APPLICANT RESPONSE TO COMMENTS (V3)
ROLLIN RIDGE ESTATES – PRELIMINARY PLAN APPLICATION (SP181)
October 31, 2018

Figure 1

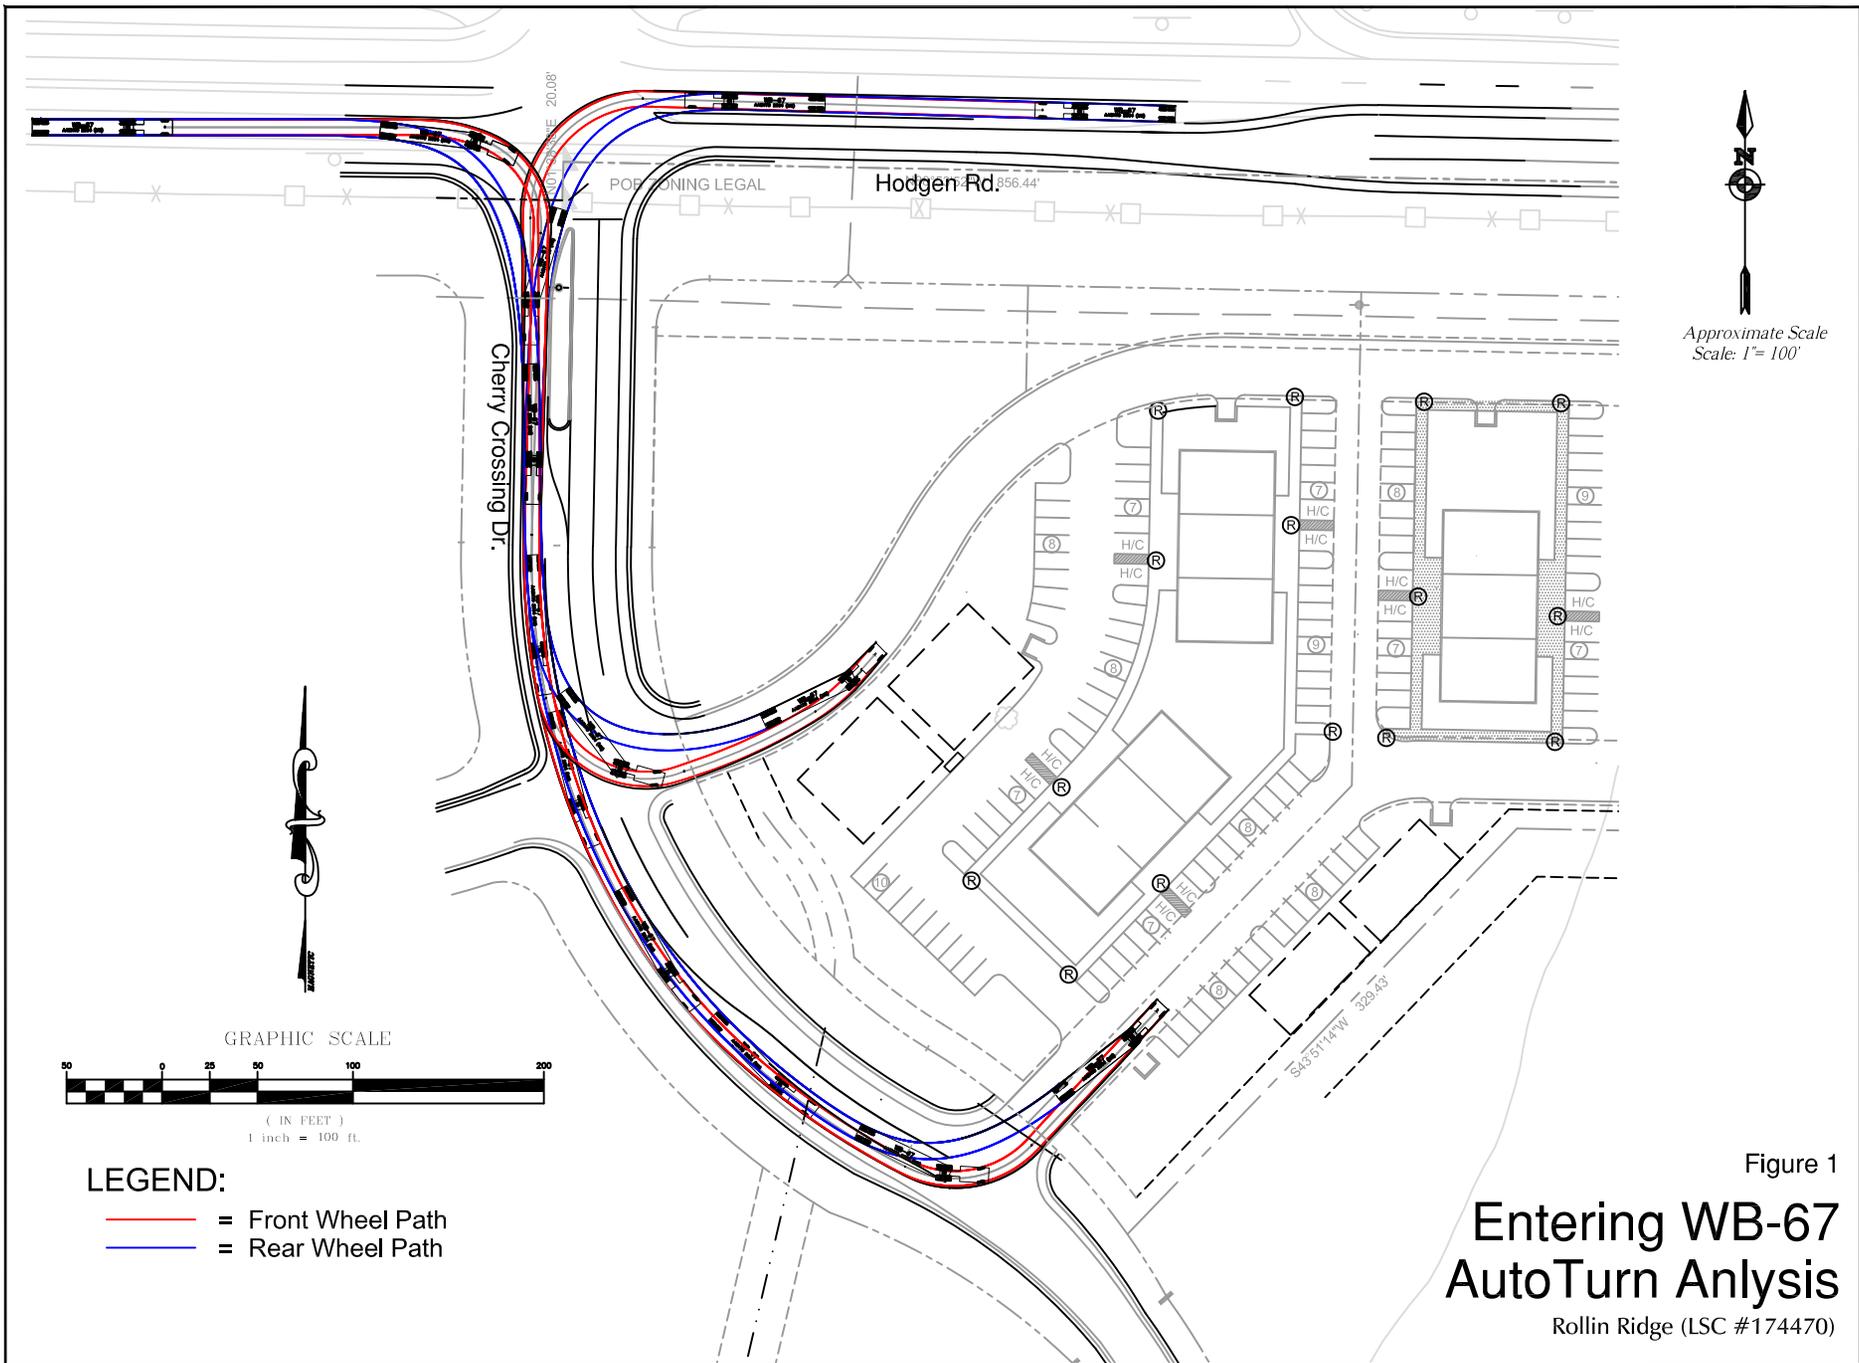
Please revise so that this truck doesn't run off the asphalt at this location.

proved scale bar please.

Reviewer cannot read the text, please provide a legend for the red and the blue lines. Please label as in movement, and the next plan as out movement.

Figure 3

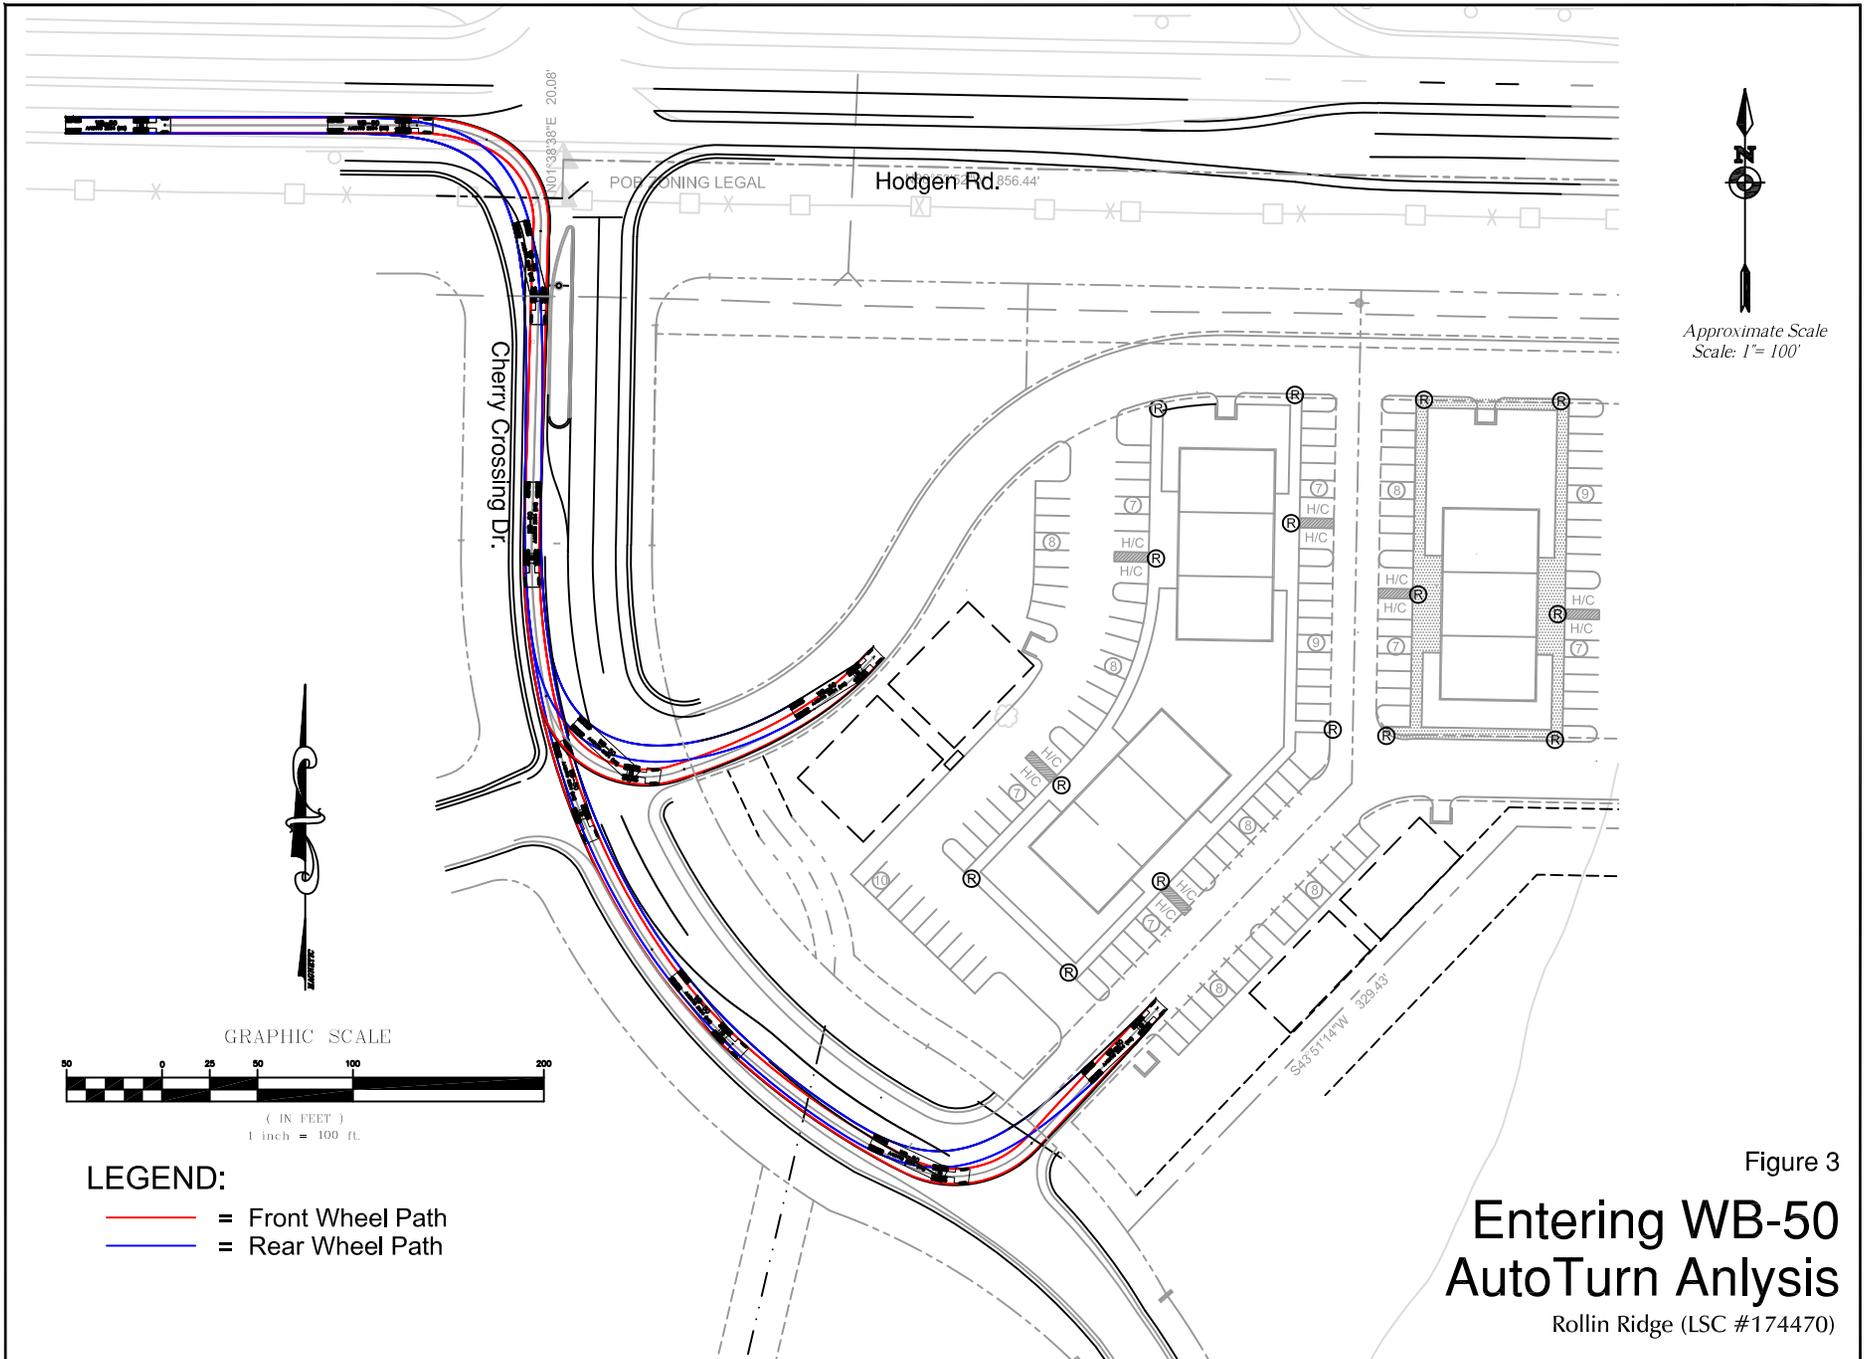
Number: 1 Author: dsdnijkamp Subject: Engineer Date: 10/2/2018 3:50:33 PM
[off the road.](#)

Number: 2 Author: dsdnijkamp Subject: Engineer Date: 10/2/2018 3:50:36 PM
[label as in or out.](#)

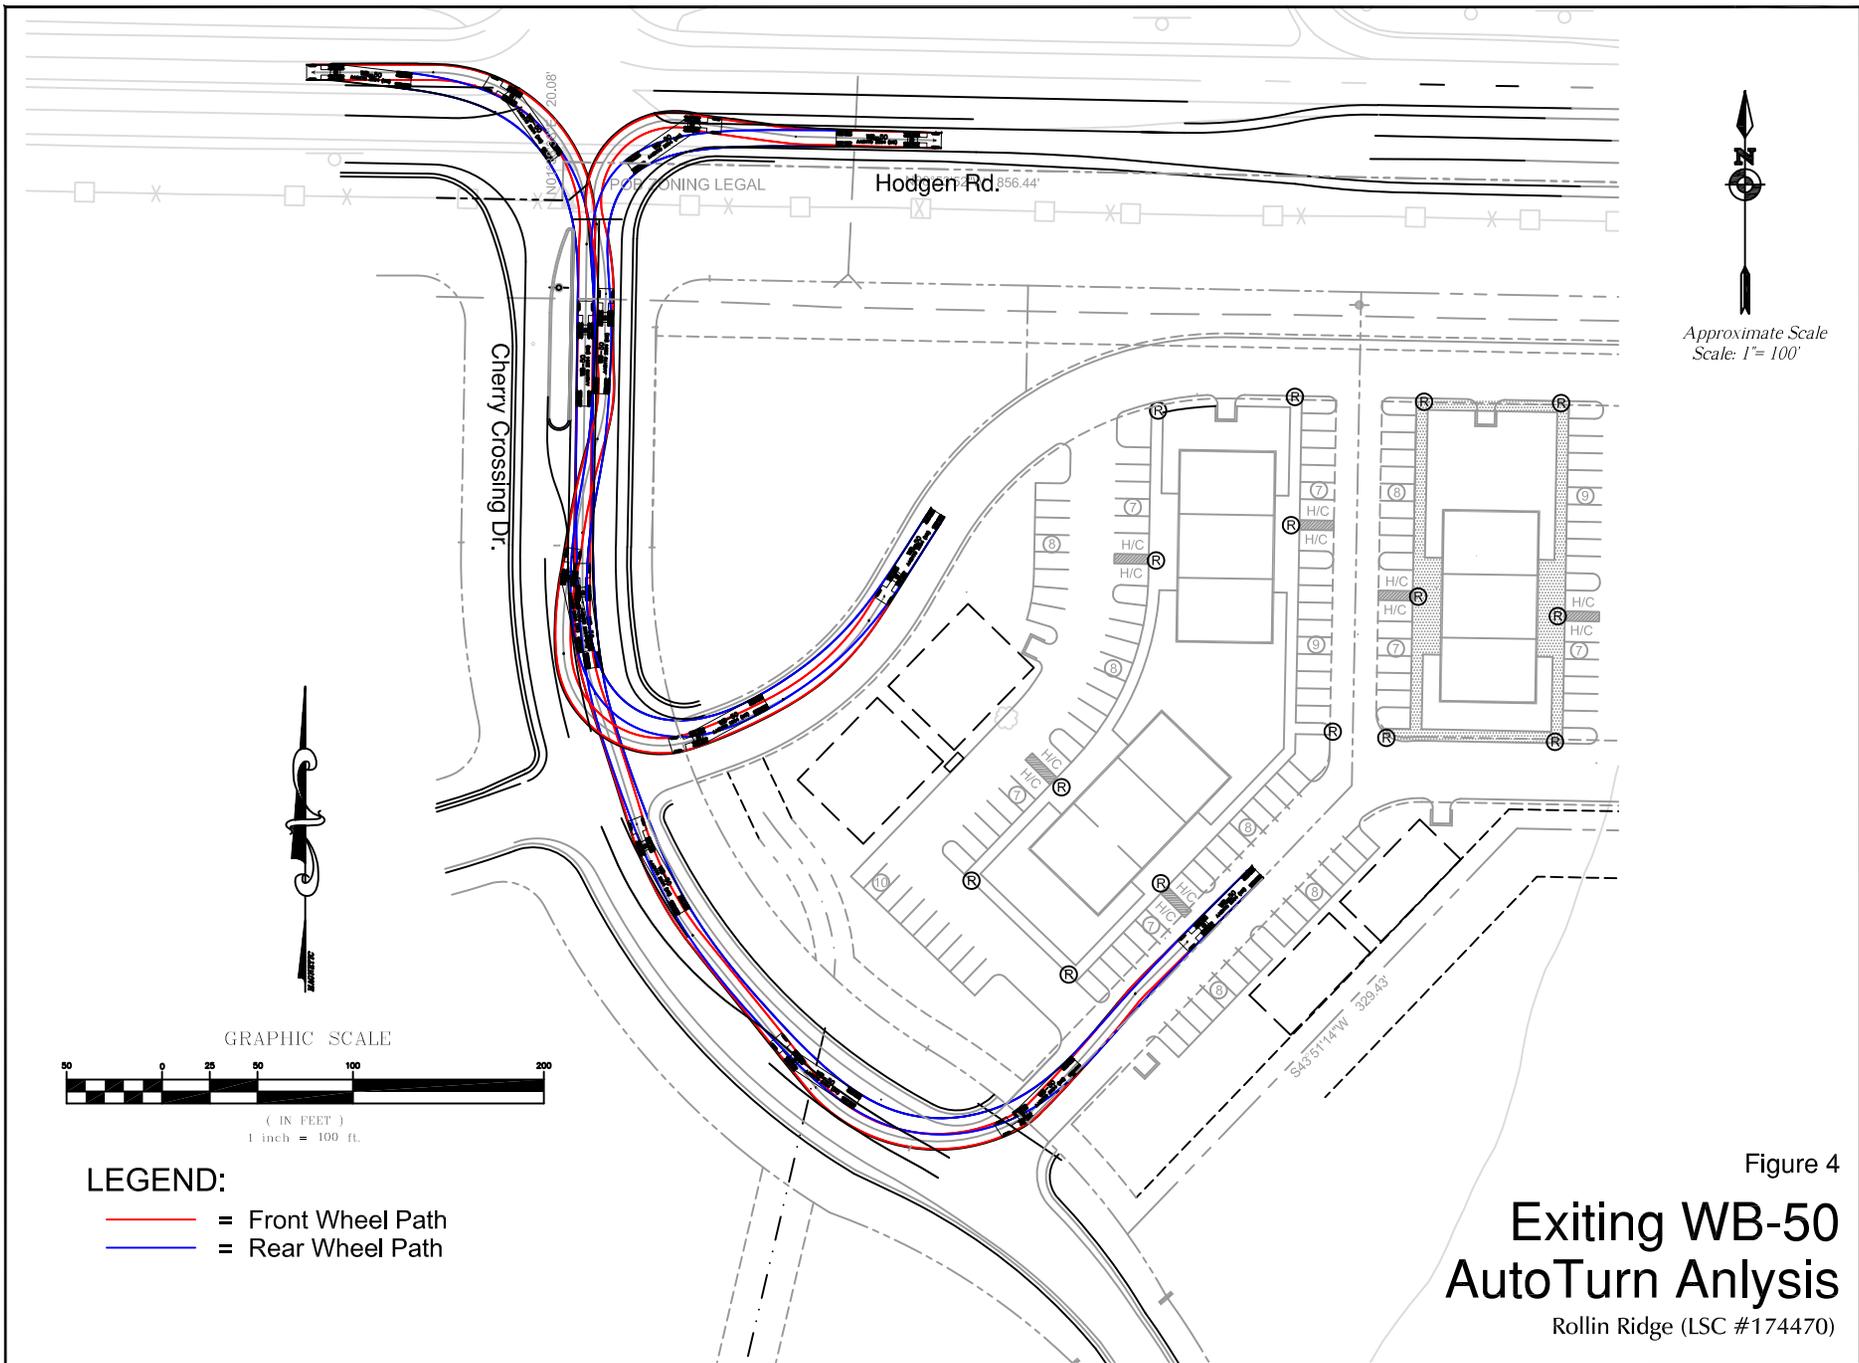
Number: 1 Author: dsdnijkamp Subject: Engineer Date: 10/2/2018 3:50:37 PM
provide a scale bar, typ all.

Site Plan

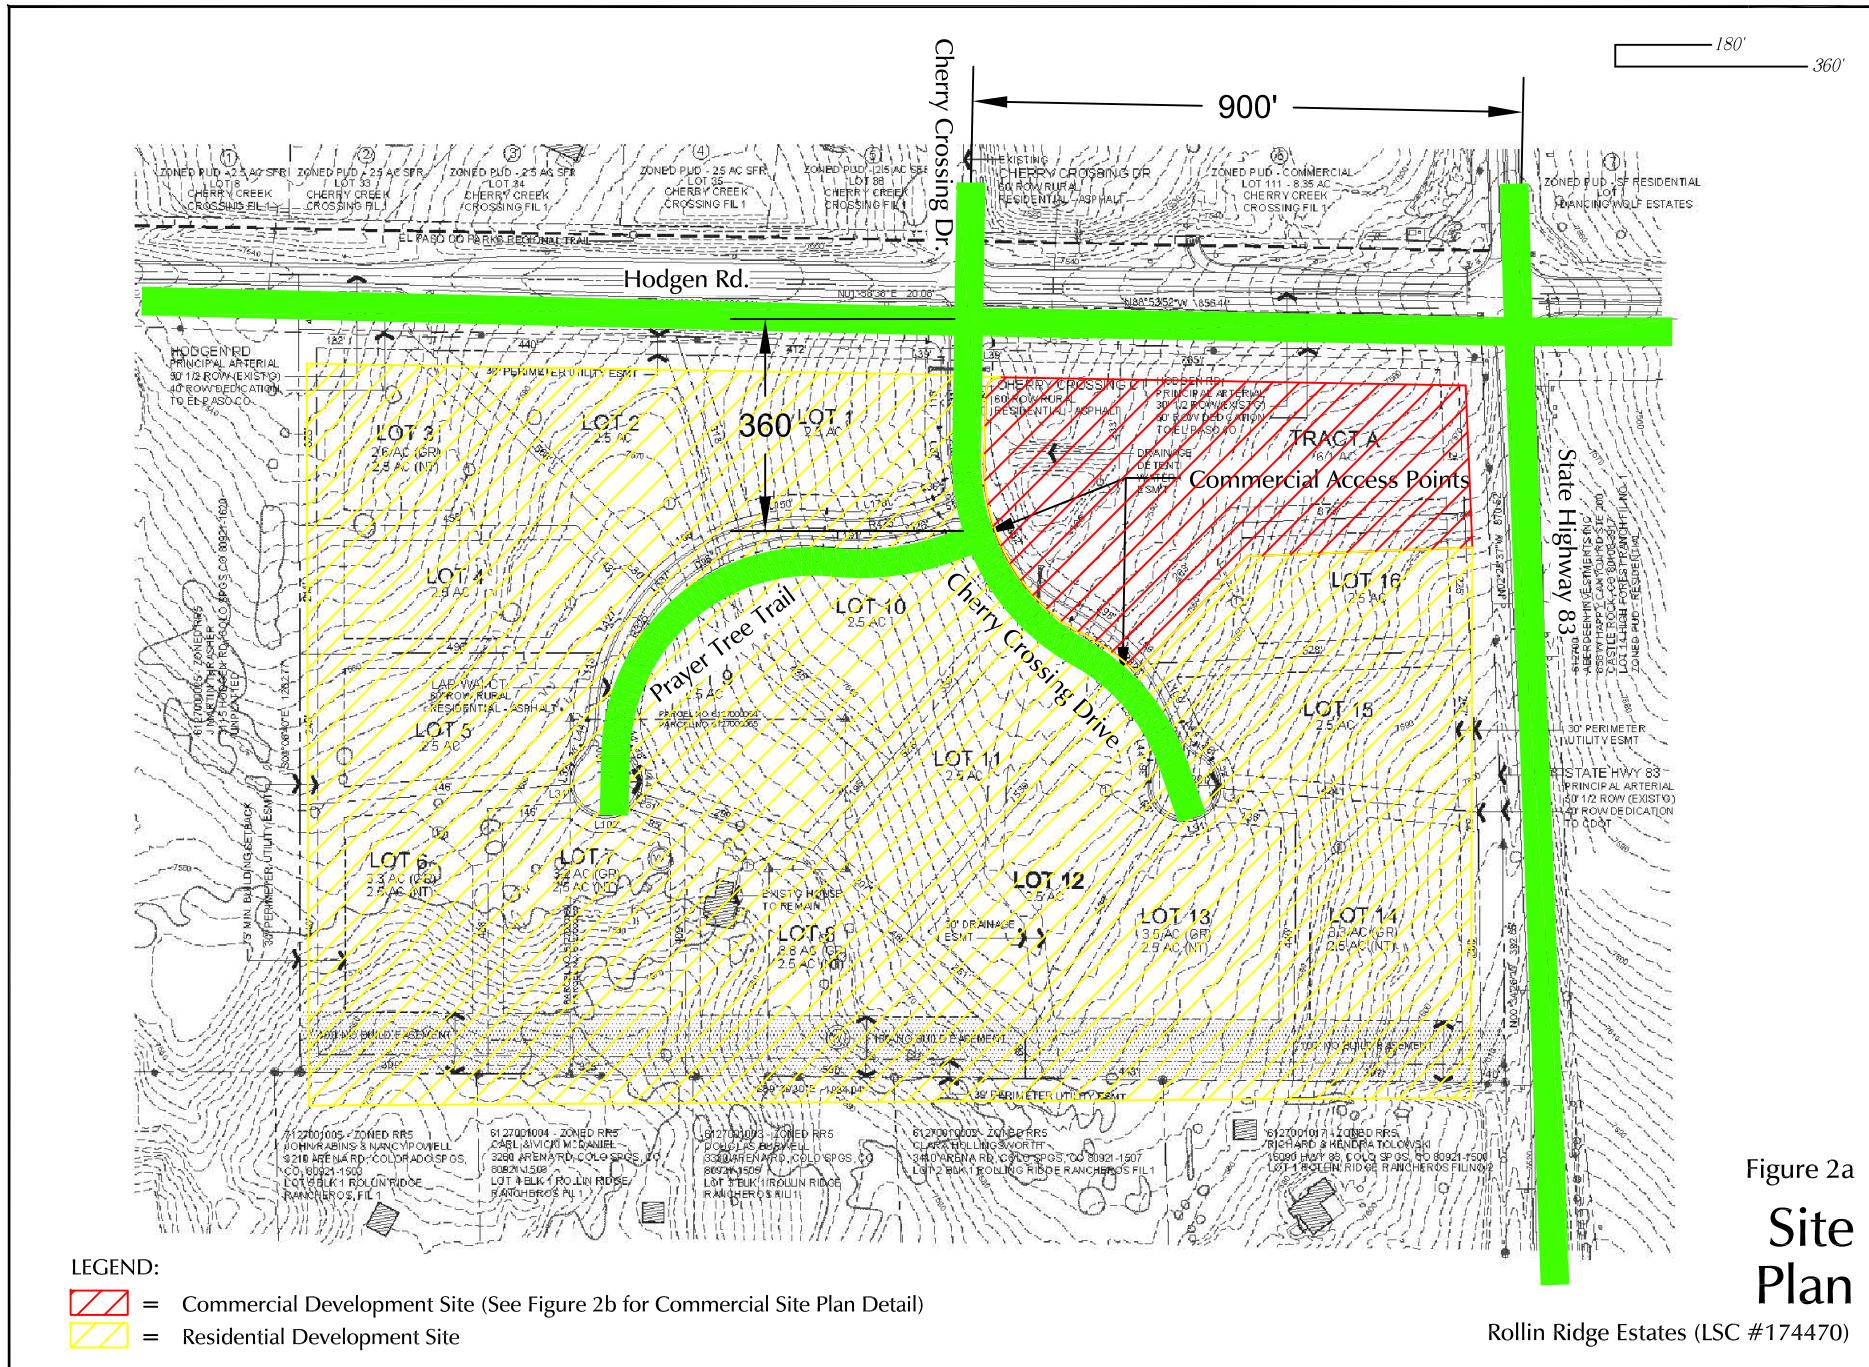
[A deviation is required for this spacing.](#)
